**Oran Park High School and Expansion of Oran Park Public School, Oran Park
Notice of Exhibition – (SSD 7968)**

Thank you for your letter dated 13 April 2017 requesting Transport for NSW (TfNSW) comment on the above proposal.

CD17/04518

Figure 5 – Proposed Bus Zone and Drop Off Areas

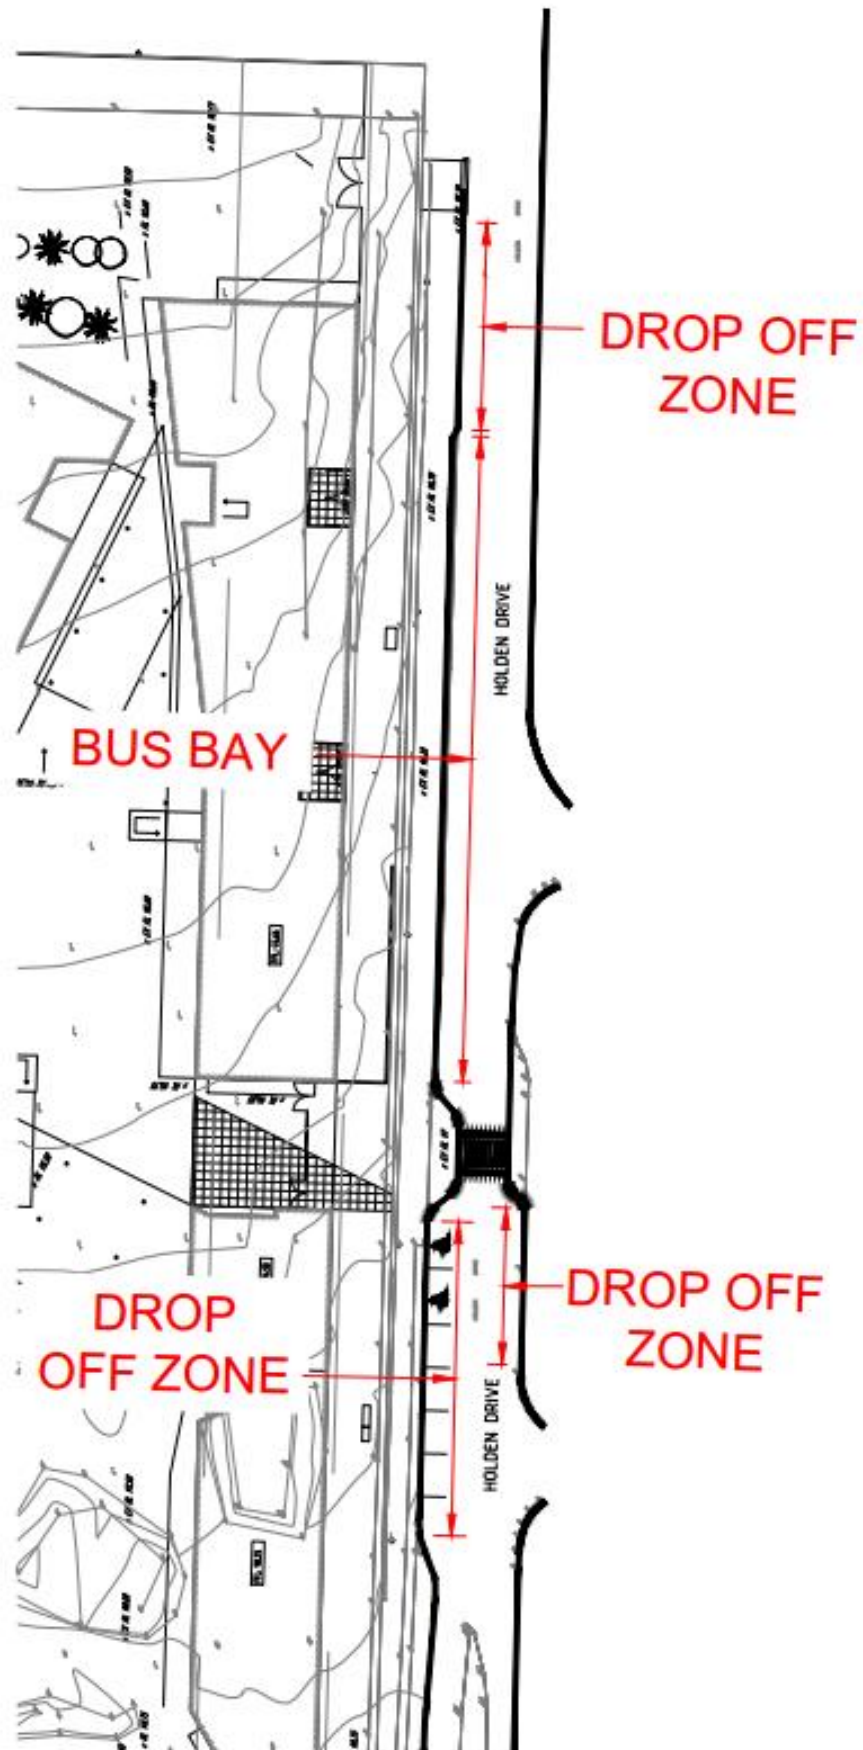
- Holden Drive, along the site's frontage, will be used for bus services and the TIA estimates that the Holden Drive connection to Oran Park Drive would be completed prior to operation of the proposed development. TfNSW recommends that the proponent engage with Council to ensure that the delivery of the link aligns with the opening of the school site to avoid any potential accessibility issues for buses.

The TIA indicates that Holden Drive, along the site's frontage, will be used for bus services and estimates that the Holden Drive connection to Oran Park Drive would be completed prior to operation of the proposed development. However, should the link not be completed, TfNSW advises that this would have a detrimental impact on the ability of buses to serve the school site.

TfNSW recommends that the proponent engage with Council to ensure that the delivery of the link aligns with the opening of the school site to avoid any potential accessibility issues.
